Botley West Solar Farm

Applicant's Responses to other D4 Submissions and
comments on Interested Parties' Responses to ExA's
Second Written Questions (ExQ2) Submitted at D4

September 2025

Document Ref: EN010147/APP/15.2

HDD 10

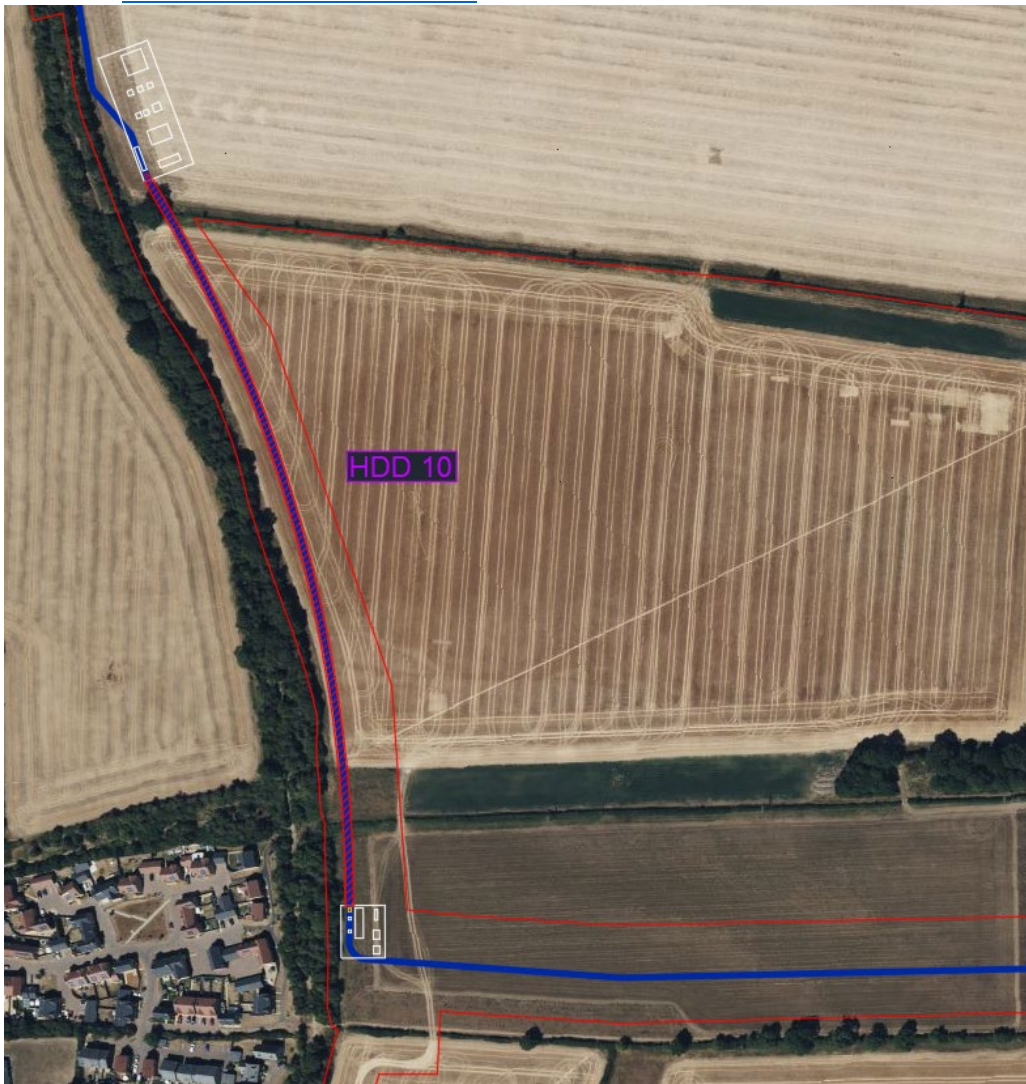
REP4-061	Environment Agency	<p>2.17.4 Landfill cabling</p> <p>With regards to potentially installing underground cabling in close proximity/ through a landfill, has the applicant sought advice from you about how best to approach this and, if so, are there sufficient safeguards in place to give you reassurance that contamination, leachate or release of landfill gases would not occur?</p> <p>Response</p> <p>The applicant is yet engage with the Environment Agency about how best to approach the potential installation of underground cabling in close proximity/ through a landfill. We have the following information and advice to offer at this time.</p> <p>As the landfill (Hensington Cutting Landfill Site) is of an historic nature and is not permitted, the regulation of the site would come under the remit of the relevant Local Authority. However, having looked at the information we do hold it appears that in addition to inert, semi-inert and biodegradable wastes, extensive tipping of asbestos also took place at landfill site, so this would need to be taken into consideration if the waste is disturbed. Any disturbance of the waste could create pathways for contamination/ landfill gas/ leachate to migrate. If the applicant chooses to proceed with the option to drill through the waste mass any arisings would have to be sampled and classified in accordance with WM3 (Waste classification technical guidance - GOV.UK) and disposed of at an appropriately permitted waste site</p>	<p>This is noted. The Applicant will consult with the Local Authority and Environment Agency post completion of ground investigation works on the extent of remedial works/installation methodology. Of note is the oCoCP which states at para 1.10.46 – “Where ground investigation identifies potential risks to sensitive receptors from contamination, a remediation strategy would be prepared and agreed with the Environment Agency/relevant local planning authority prior to its implementation.”</p>	Cable_Routes
